From: Richard Temple
Sent: 14 November 2017 16:20
To: Karen Garner
Subject: FW: Wellow Barn, Hoe Lane, Flansham Bognor Regis. Y/56/17/HH
Attachments: Prop Site Plan 100 1.pdf

Application Number	Y/57/17/L AND Y/56/17/HH
Address	Wellow Barn Old Barn House Hoe Lane Flansham PO22 8NT
Description	Application for Listed Building Consent for a Detached carport
Case Officer	<u>Mr R Temple</u>
Date	14 th November 2017

The application is for a substantial carport with integral log store.

PROPOSED PLOT PLAN

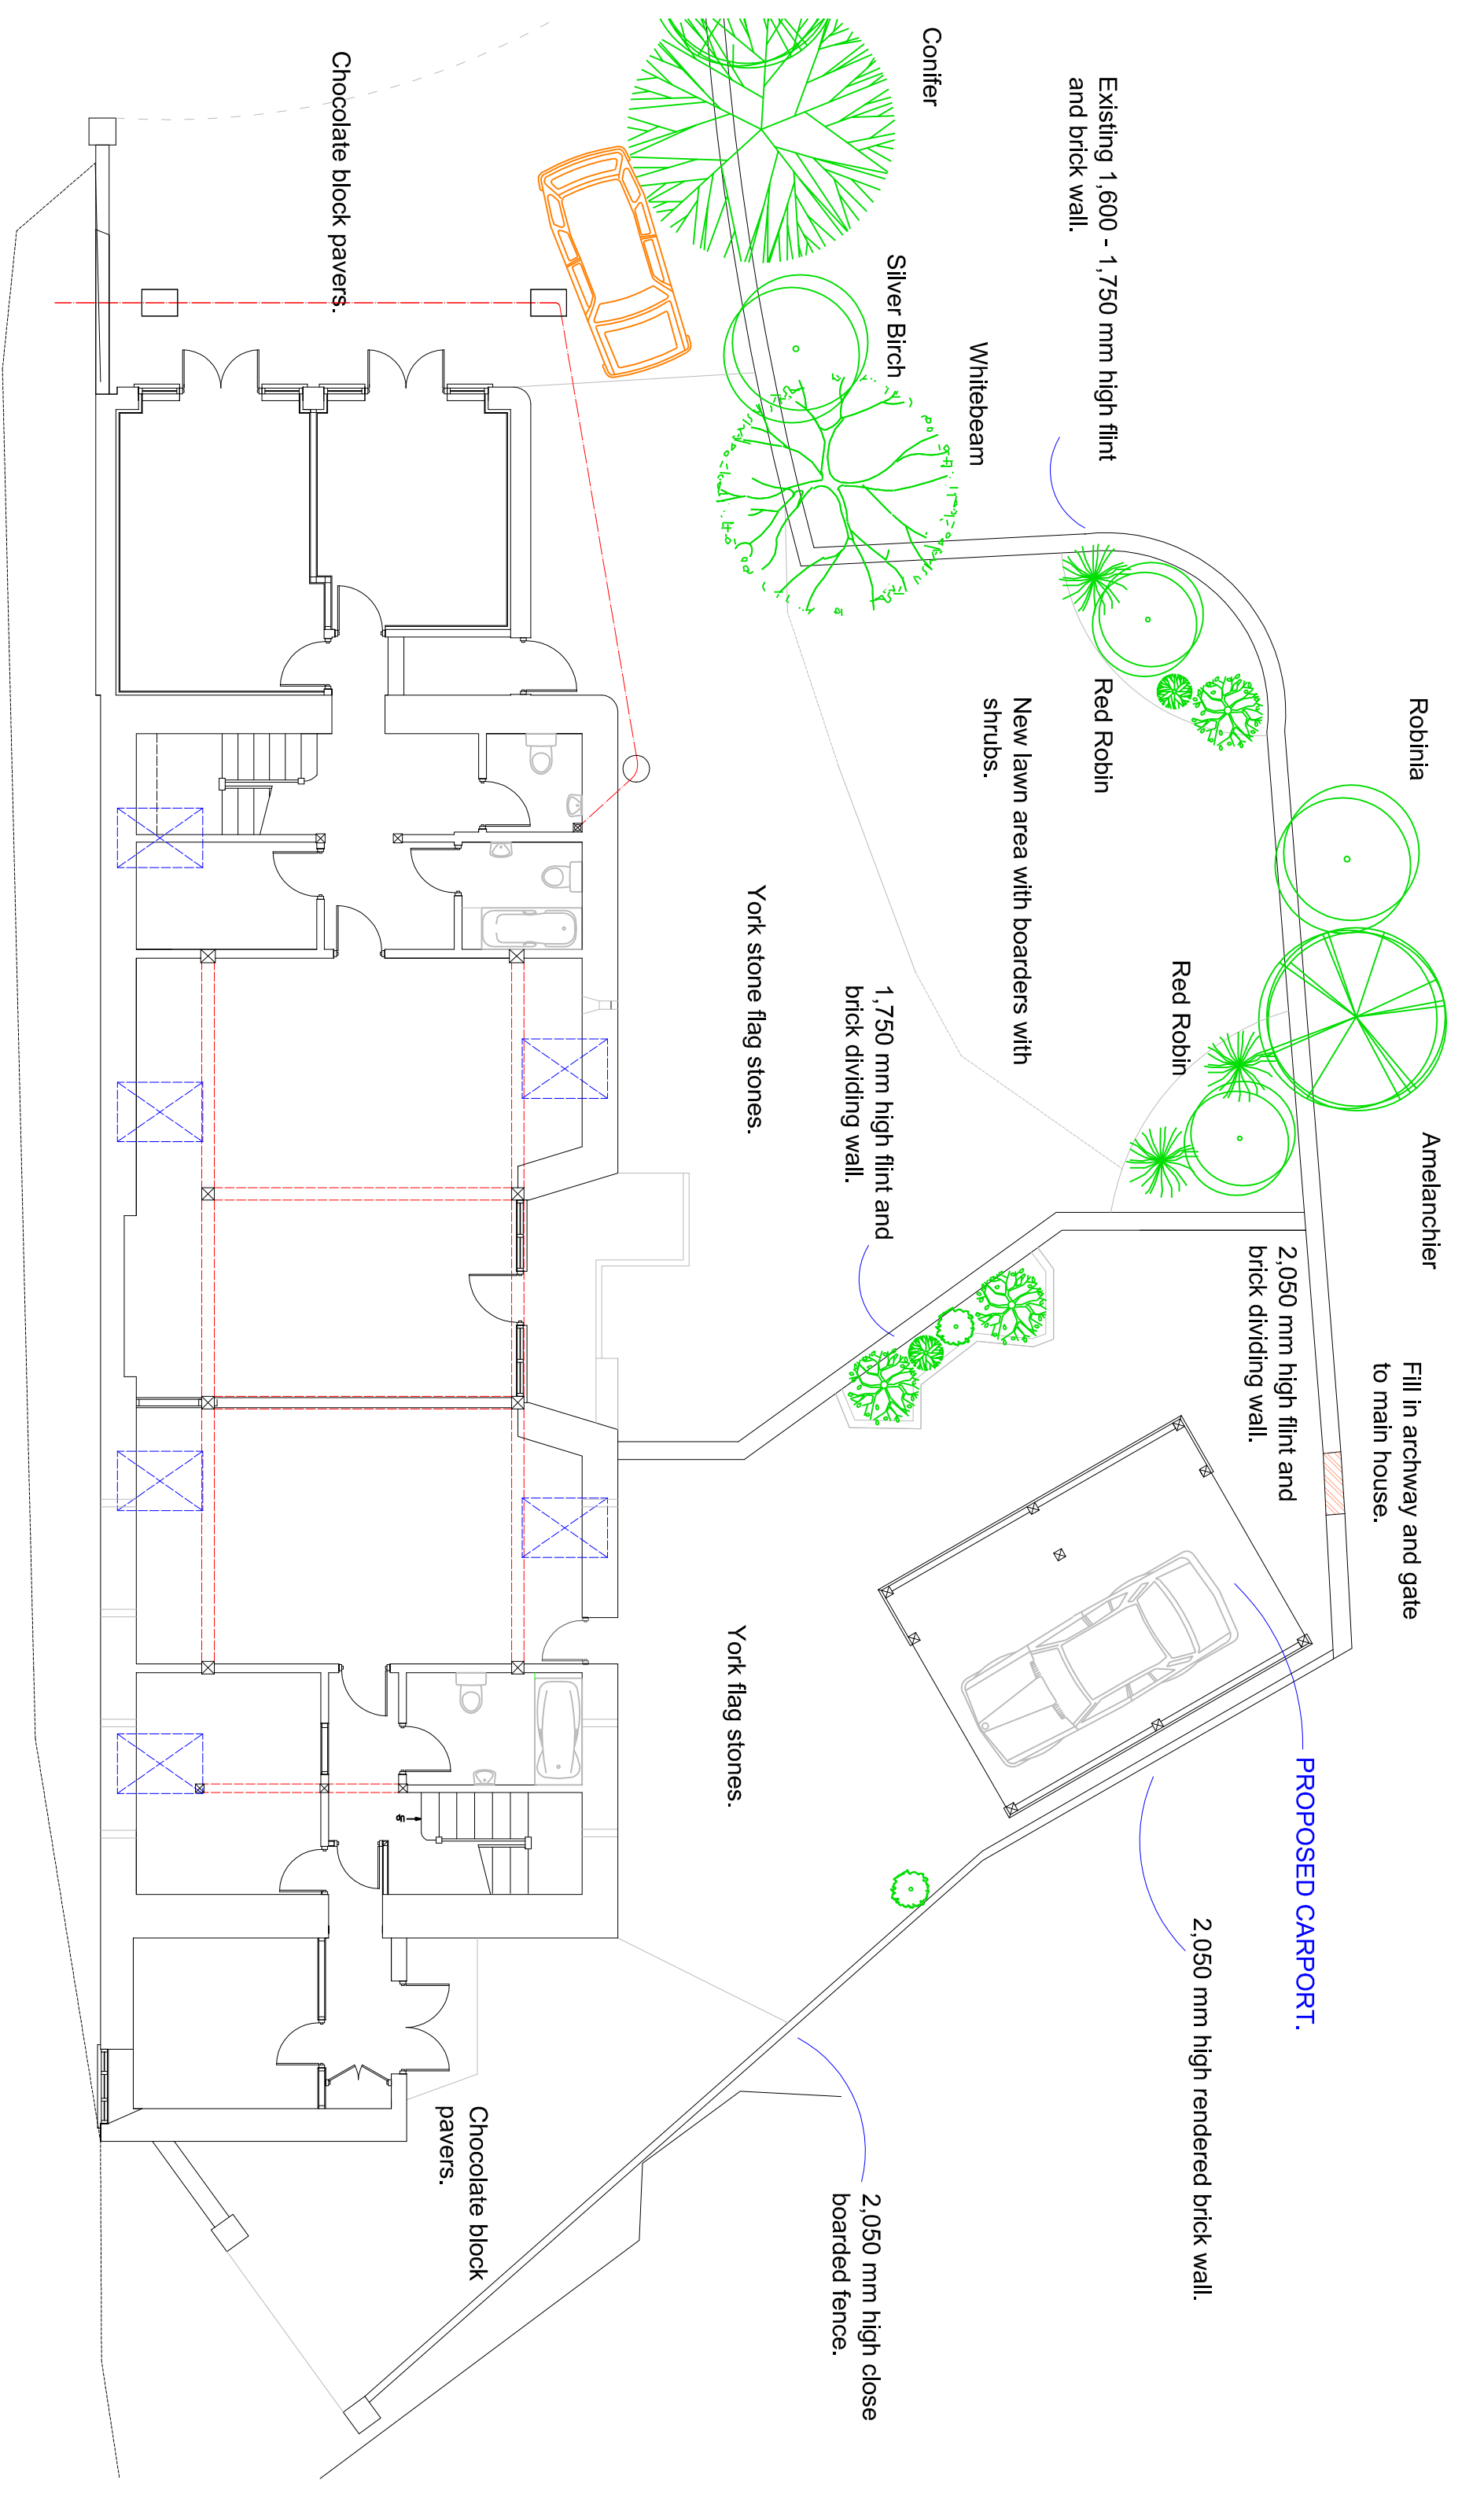
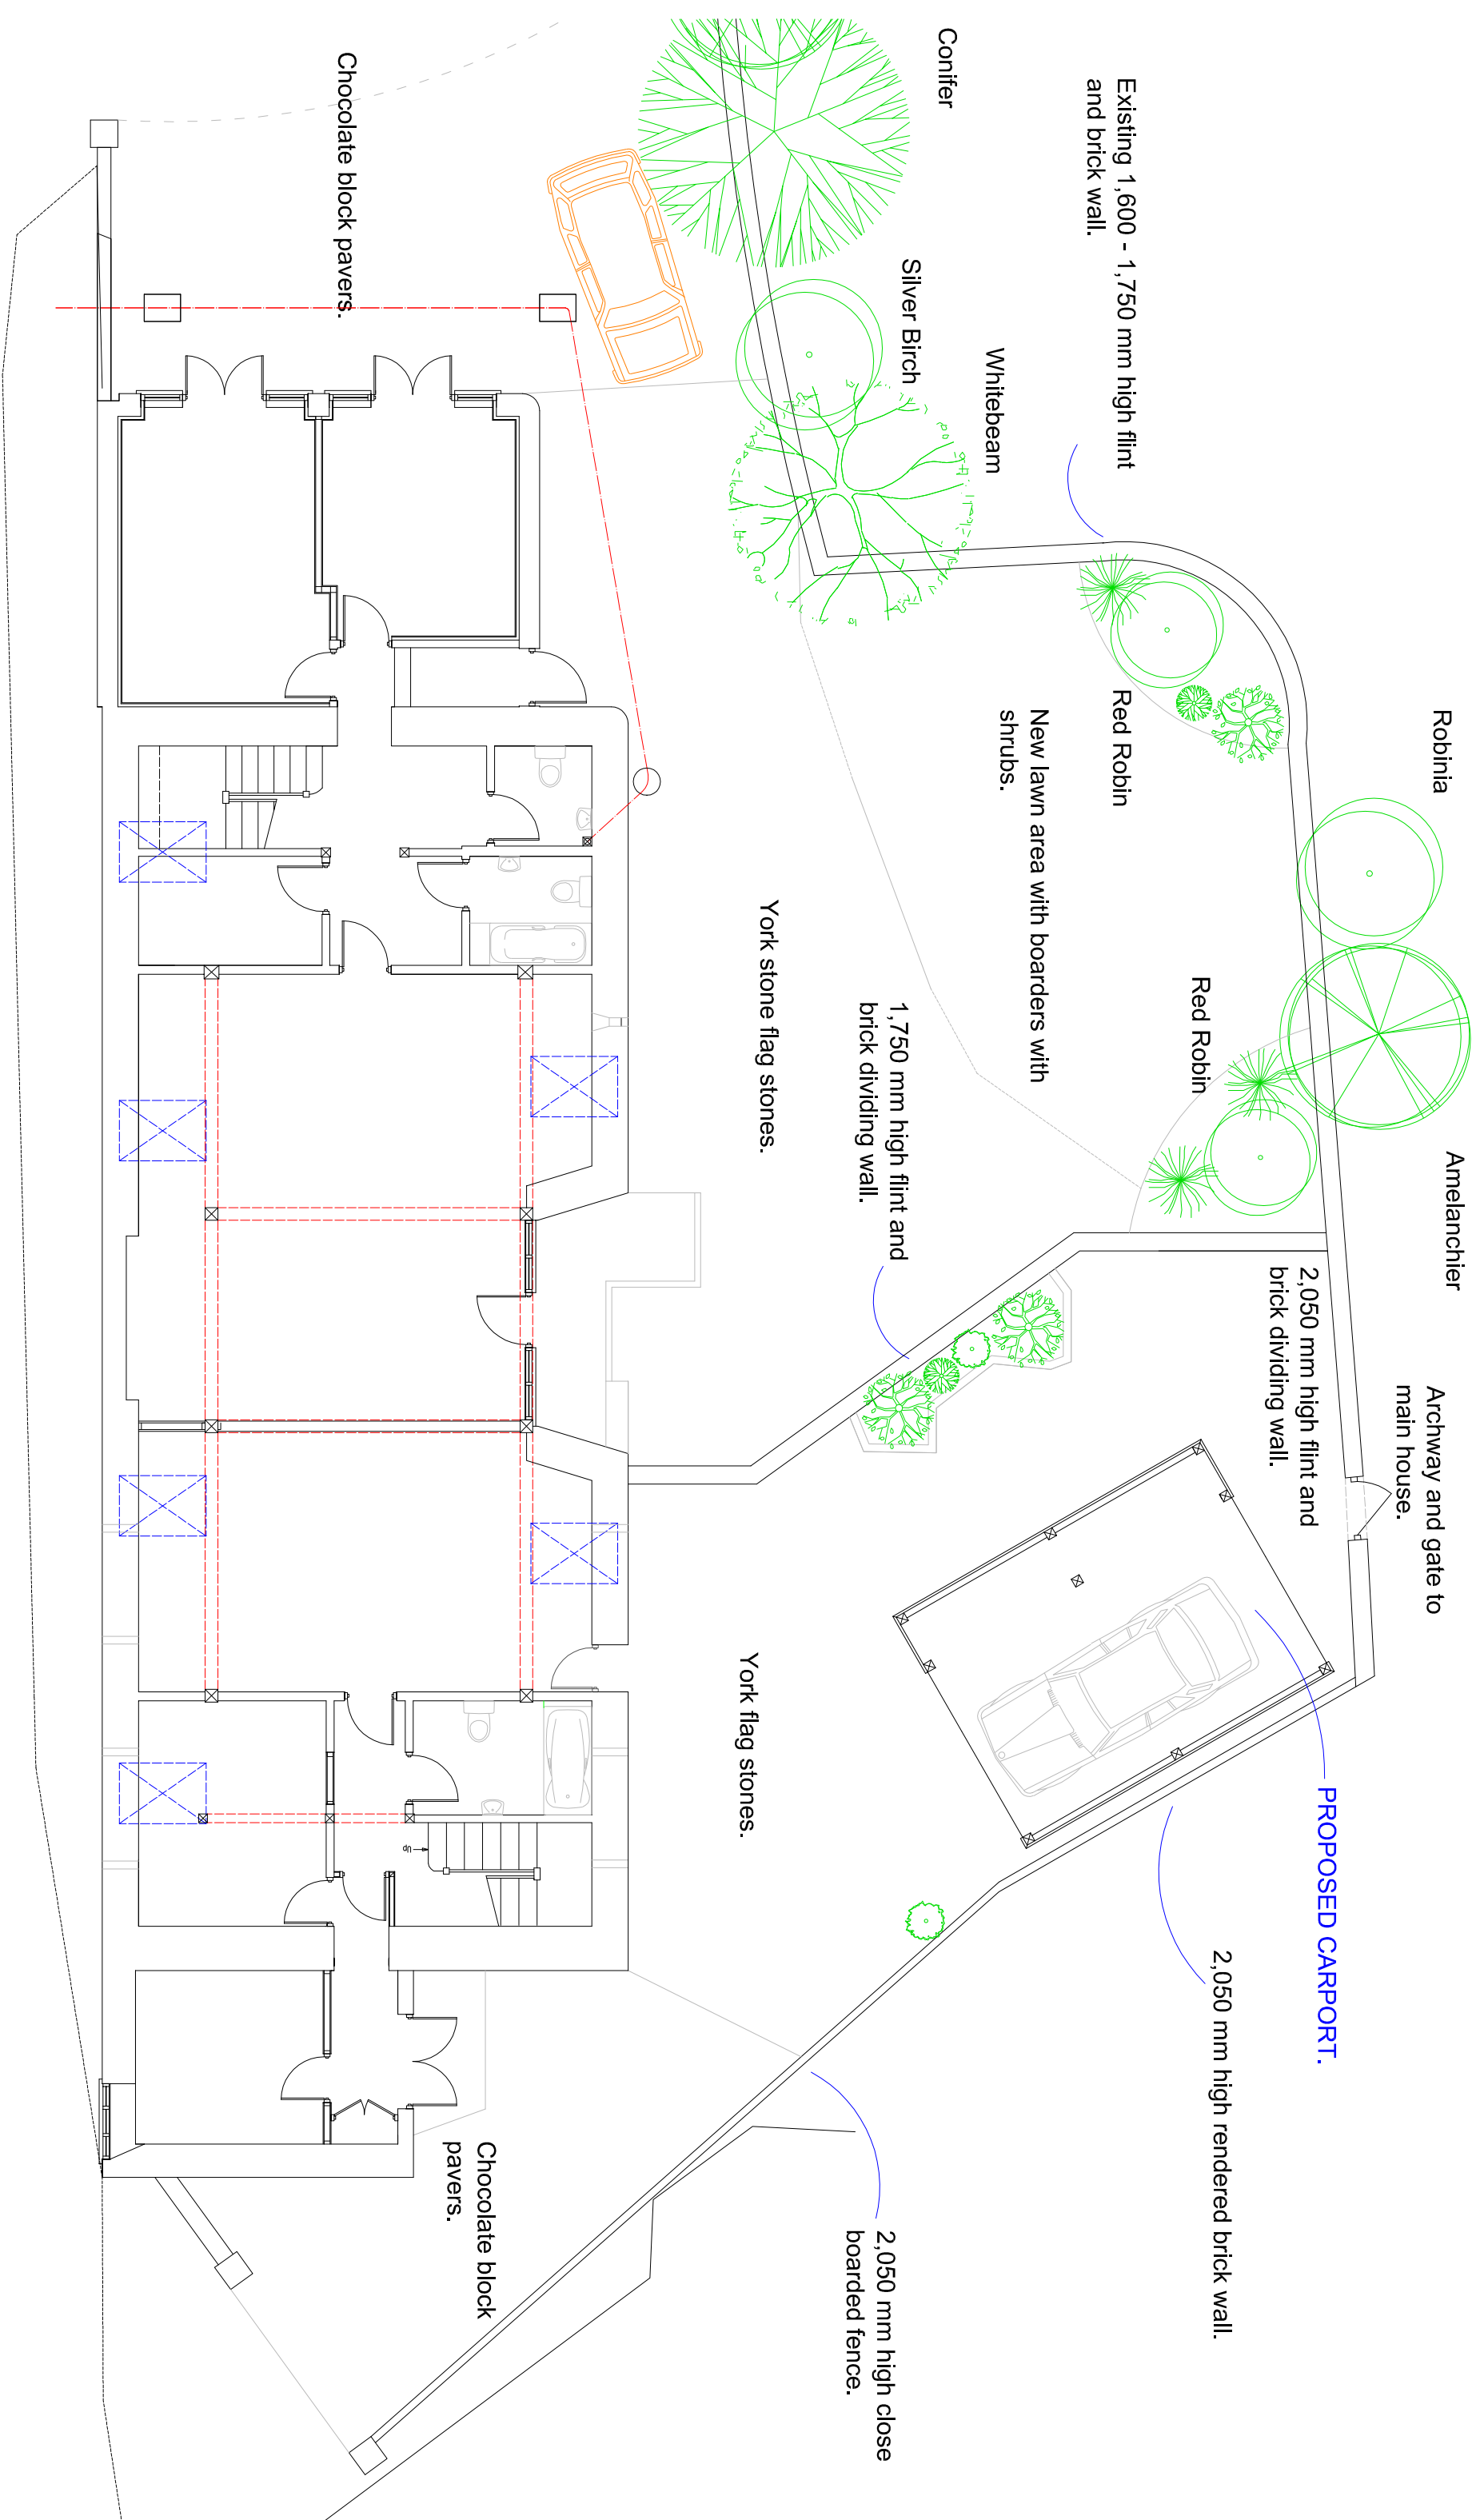
The proposal also details the blocking up of an existing, historic gate. This element represents a historic link between the house and ancillary buildings, and it is recommended that this feature be retained, and not blocked up as detailed on the submitted plans.

Please let me know if you are willing to omit the blocking up of the door from the proposals. We would also look to include a pre-commencement condition for the exact details of proposed materials.

Regarding the Conservation Officers comments – I attach revised plans retaining the gateway as requested. I hope that this allows you to process the applications/s towards a positive decision and I look forward to hearing from you.

PROPOSED GROUND FLOOR PLAN

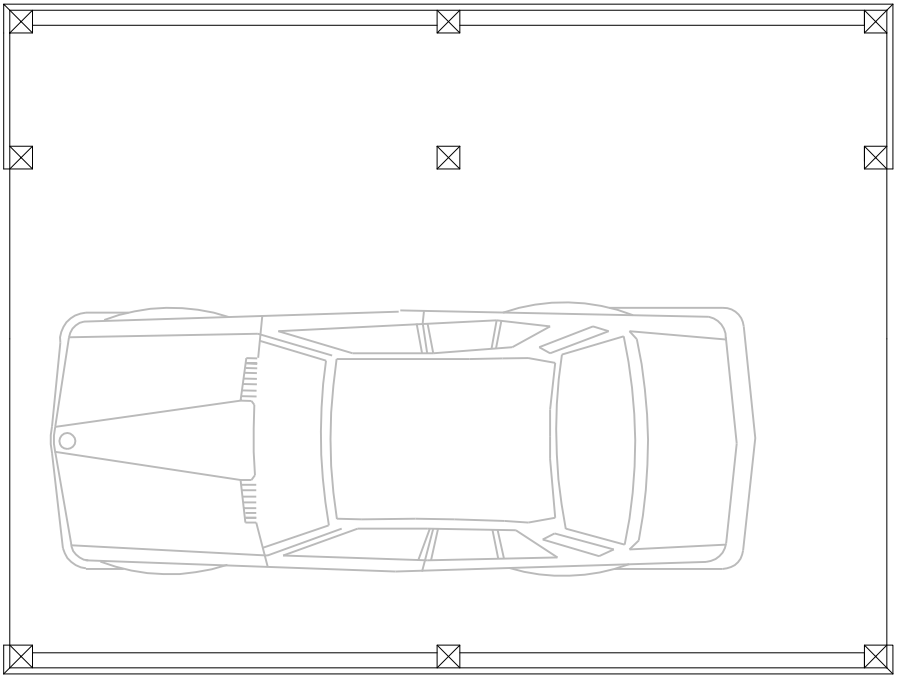
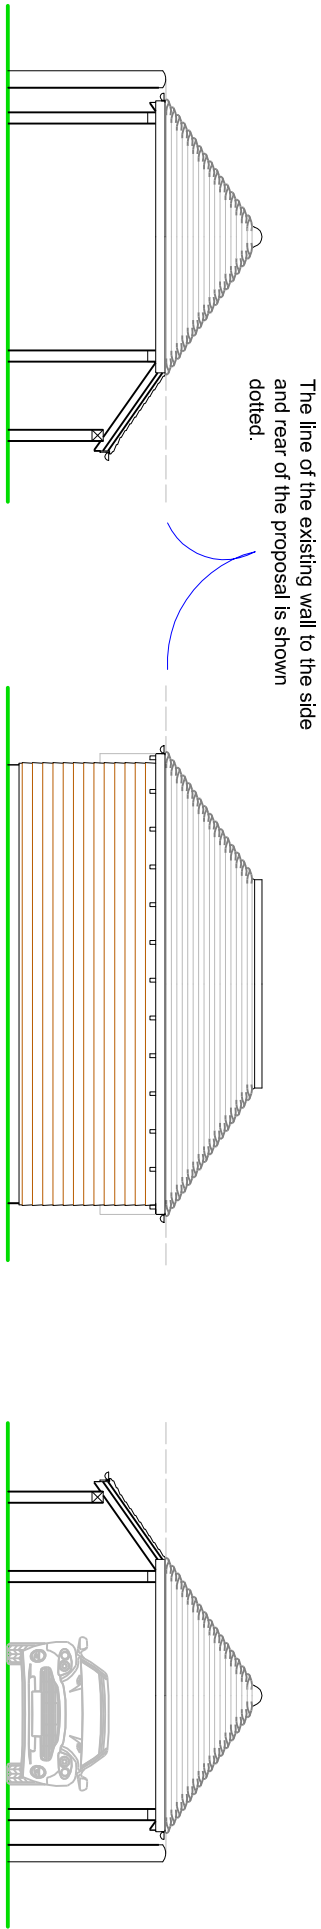
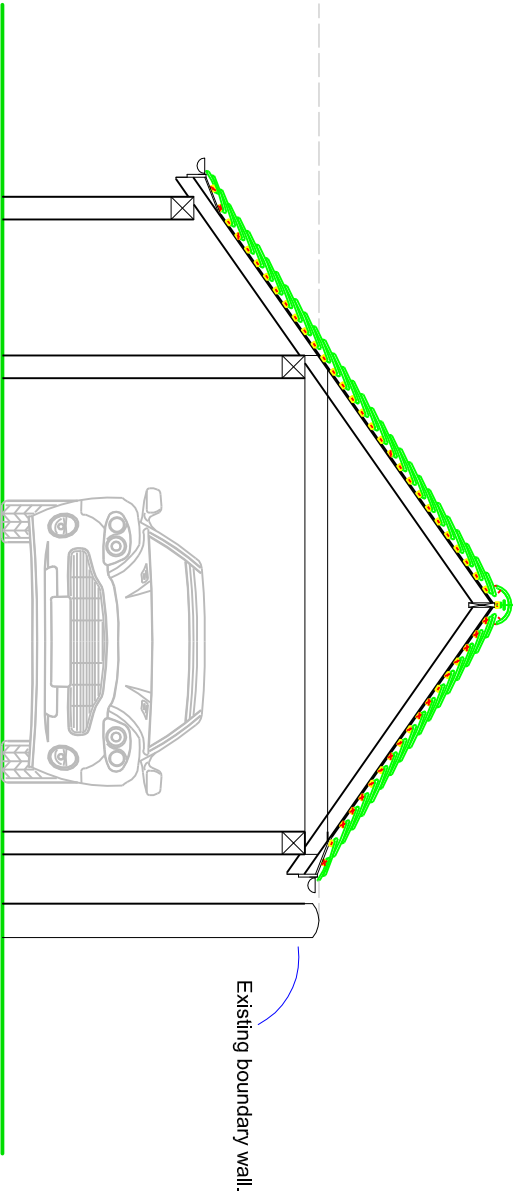
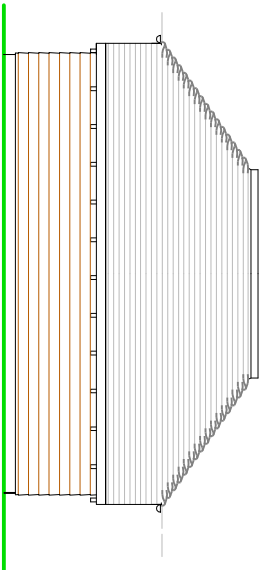
The proposed will be dominating within a small plot, and visible from the street scene. It is considered that the development, constructed in the proposed material pallet would not represent substantial harm to the setting of a listed building.
